Planning Statement

Residential Development
163 Laund Road
Salendine Nook

Client
Job No. 22D17
26.04.23

This Planning Statement is in support of application number 2023/90641 - erection of 4 dwellings and partial demolition and extension of 163 Laund Road: This is a resubmission of a previous application 2022/92802, for a similar development.

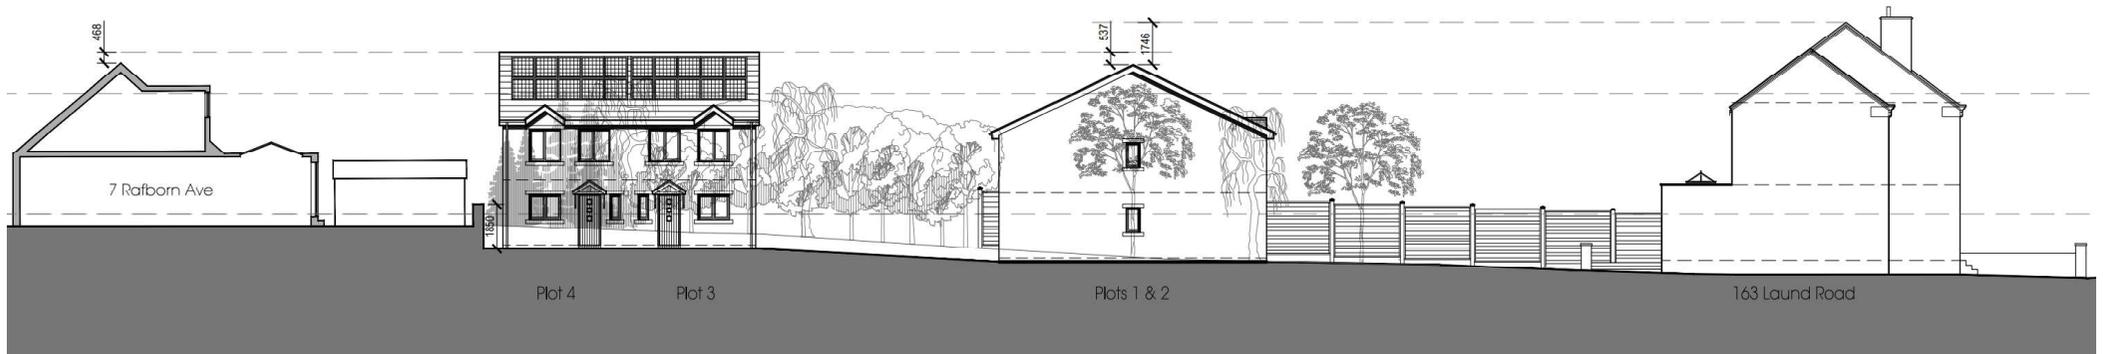
Page 10, paragraph 1 states that our proposals were greater in height than that of the existing house, again another inaccuracy of the planning officer's report. The ridge height of the house is 10.4m above ground level and the original proposals were 9.9m above ground level as the officer's report states. We have however taken on board the officer's comments and reduced the height of the proposed dwellings as can be seen on the site section below.
